Mandy Richardson  
Clerk to Whalley Parish Council & RFO  
14 Black Lane Croft  
Chester Avenue  
Clitheroe  
BB7 2EZ

10 February 2021

**Whalley Parish Council Response Planning Application 3/2020/0076 Queen Mary Terrace and Bridge Terrace - Whalley**

Mitton Road, Whalley

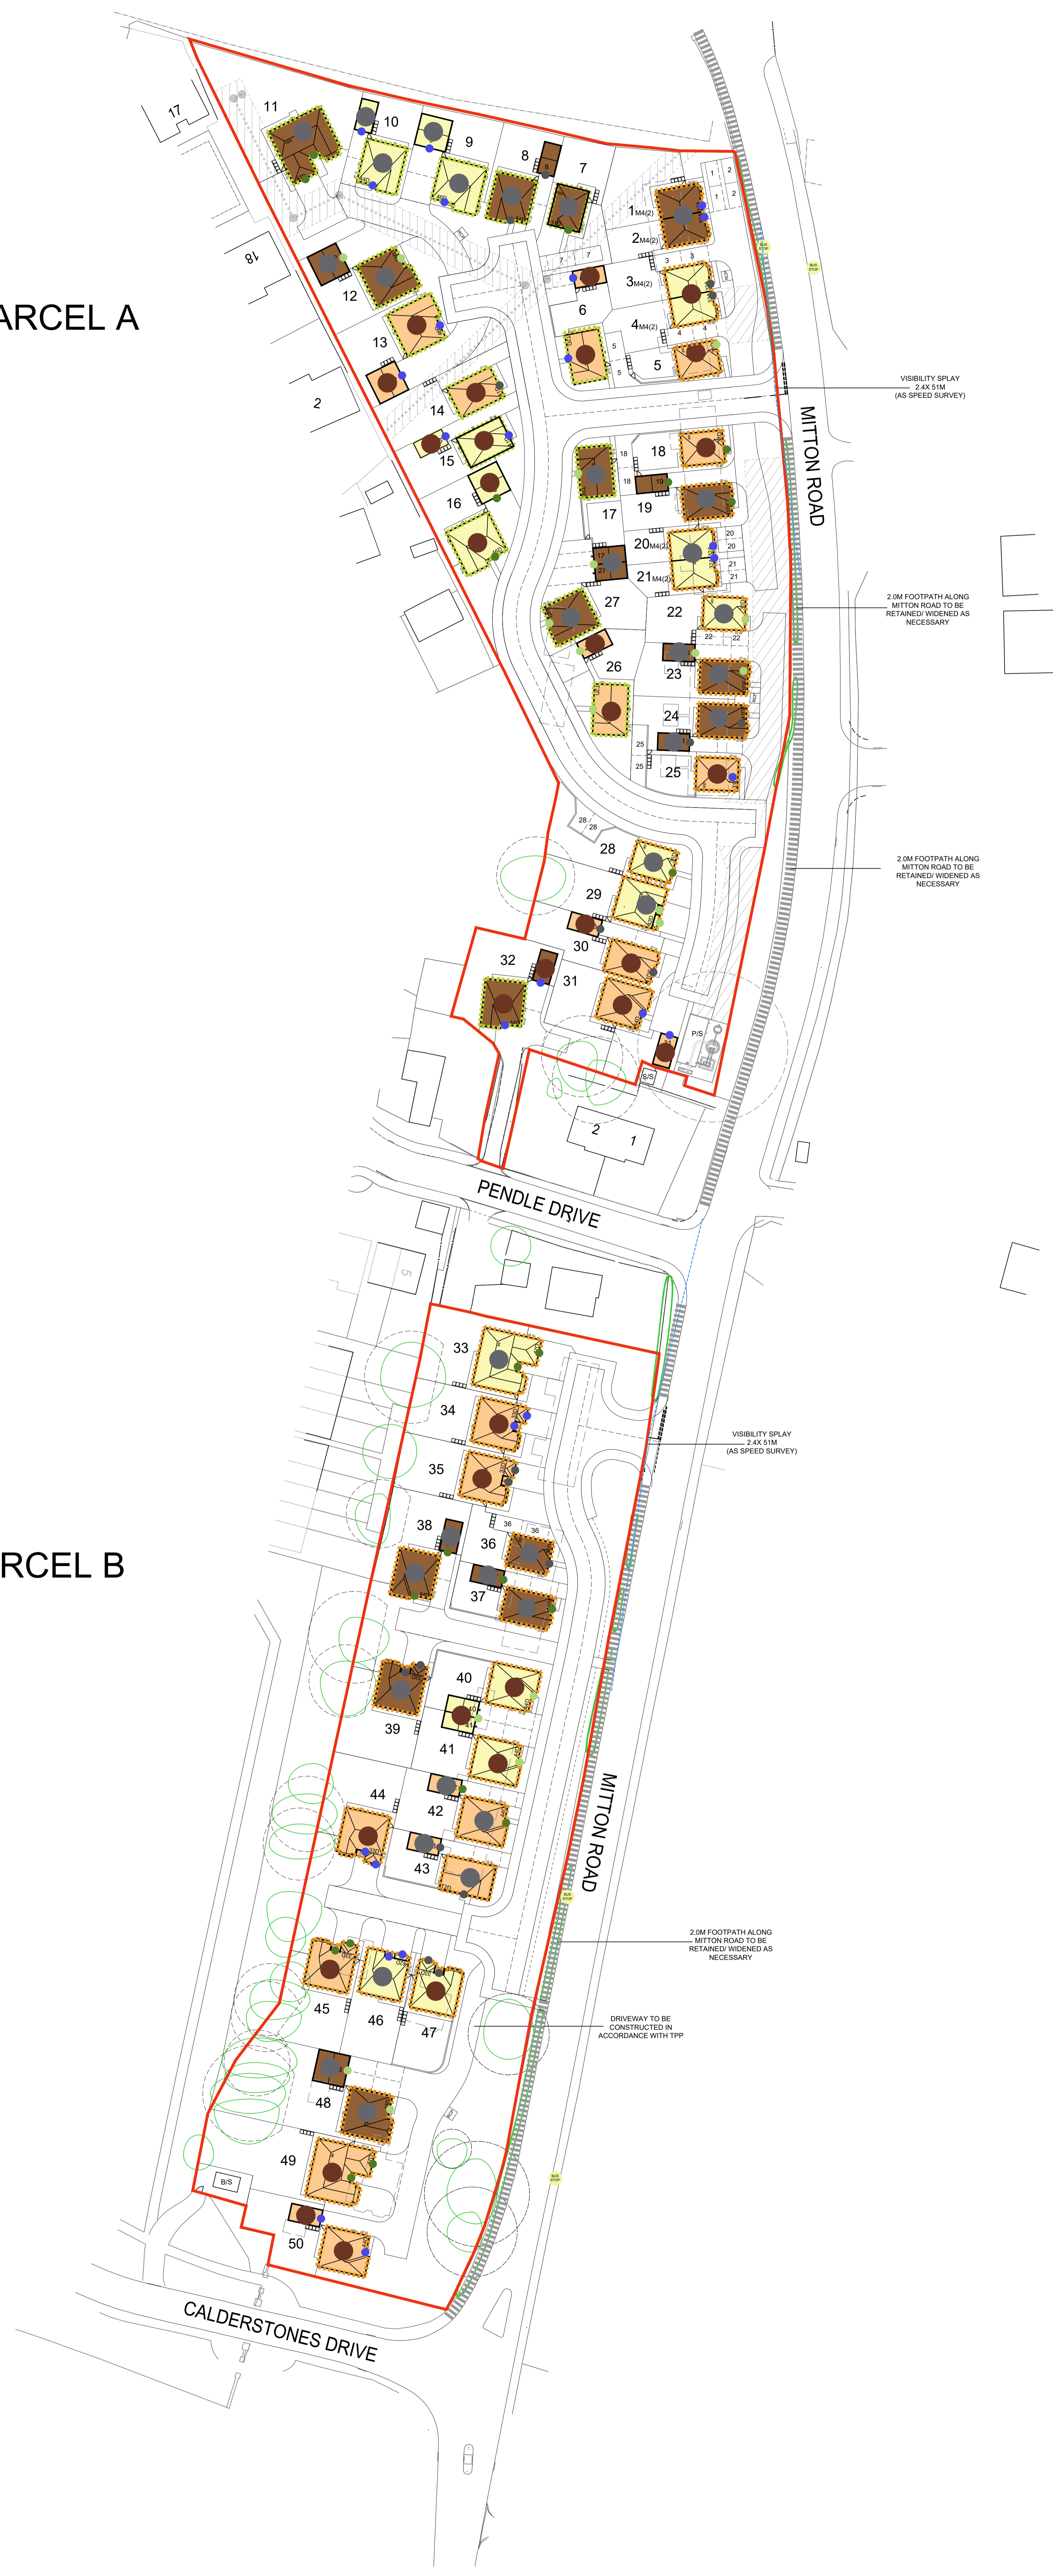
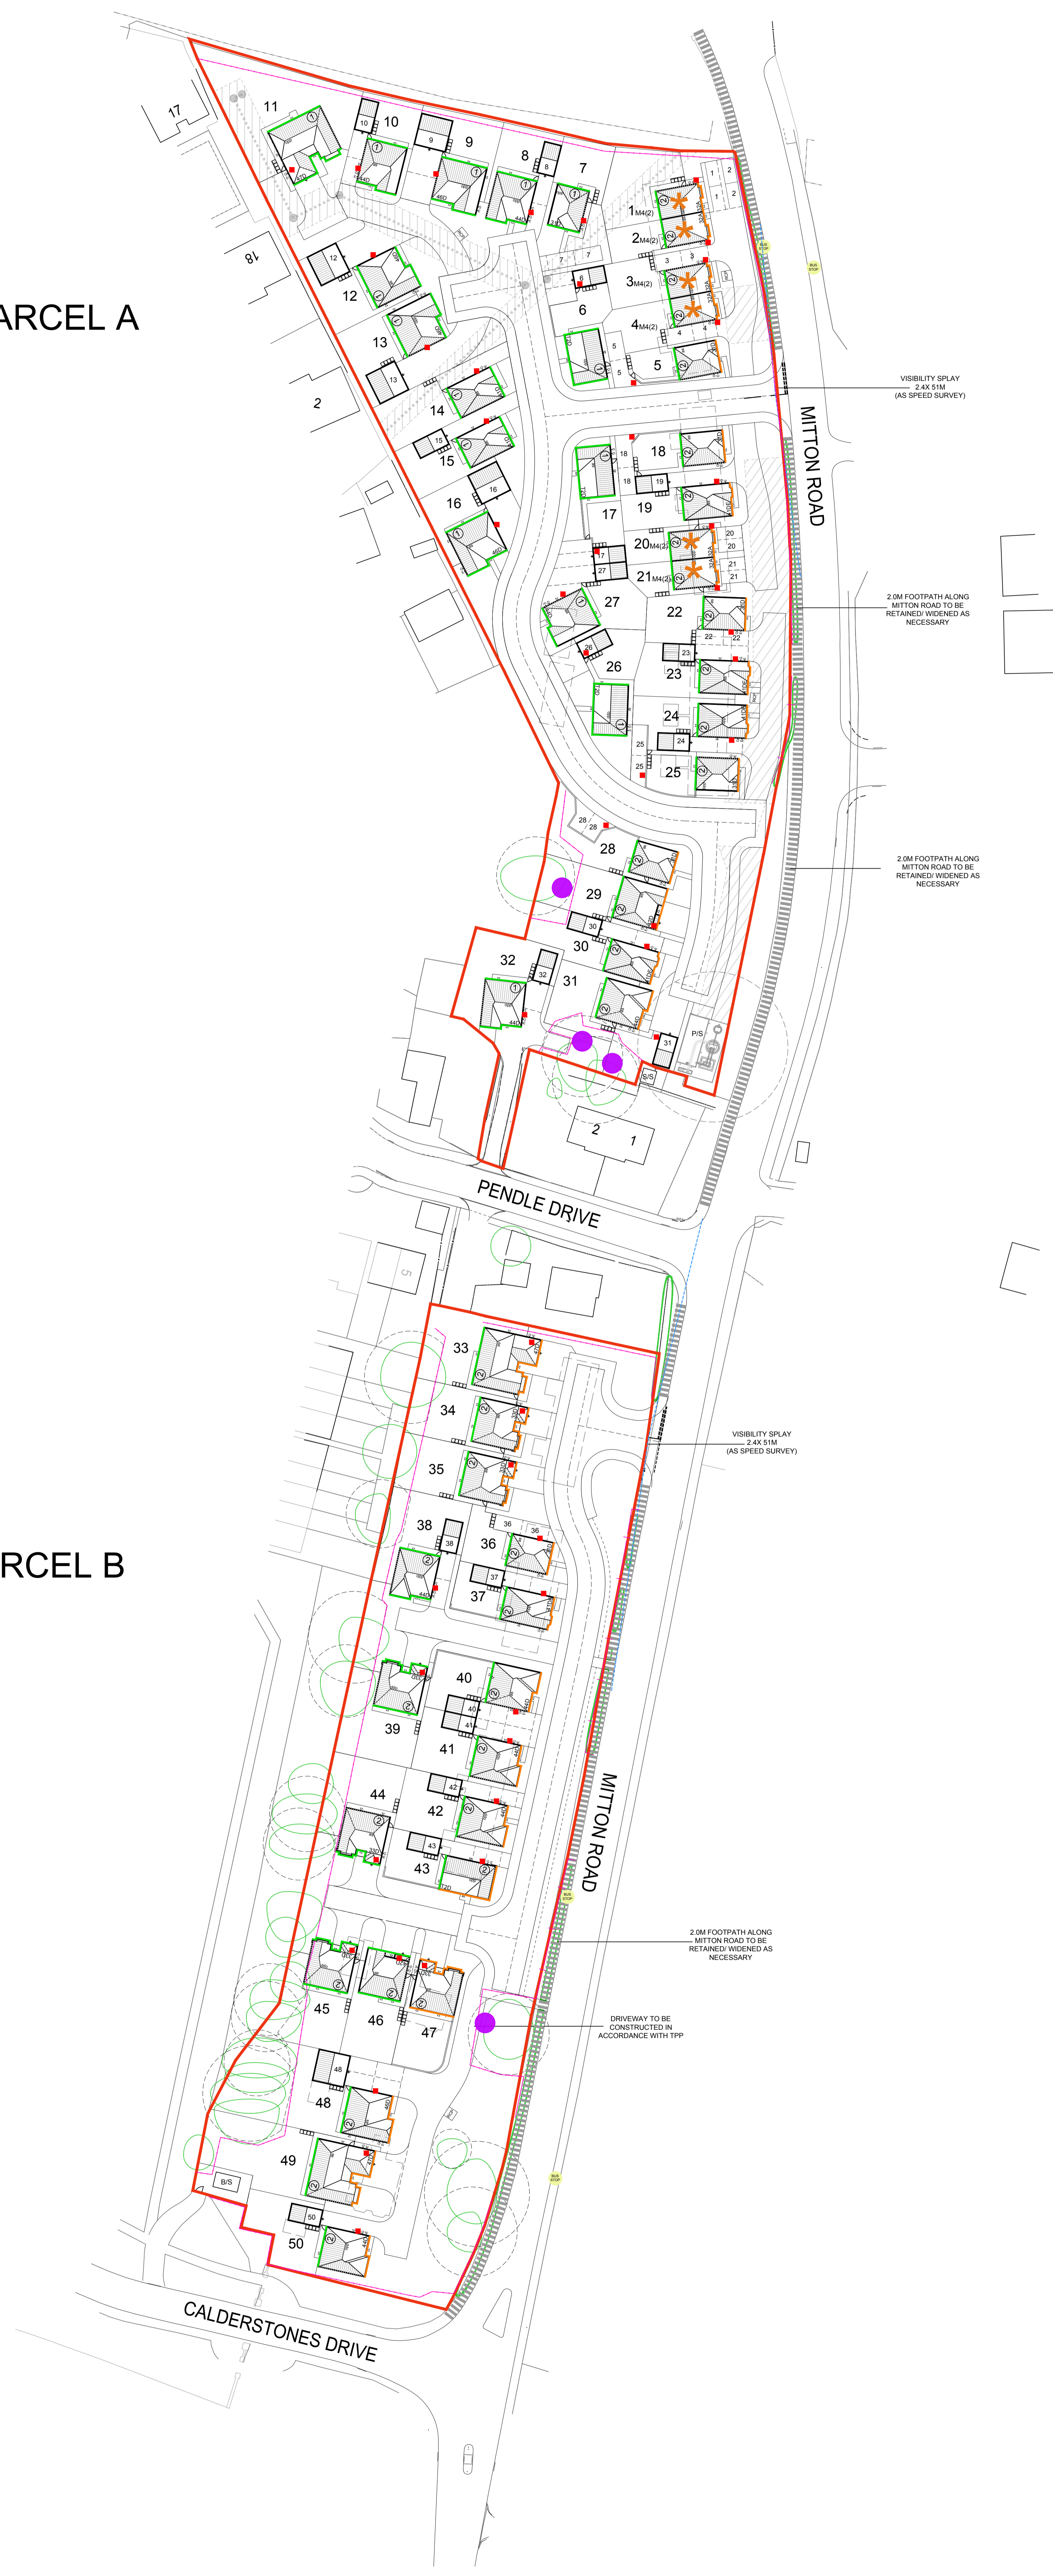
Whalley Parish Council believes that the proposal for two additional access roads either side of Pendle Drive is questionable on safety grounds. The existing properties on Bridge Terrace and Queen Mary Terrace have been empty for a considerable time during which there has been no contribution to traffic flow.

**At the very least 'calming measures' along Mitton Road must form part of any conditions which lead to an approval of this application. The Parish Council strongly recommends that Ribble Valley Borough Council puts in place a S278 agreement with the developers, in order to promote the 'calming measures' along Mitton Road.**
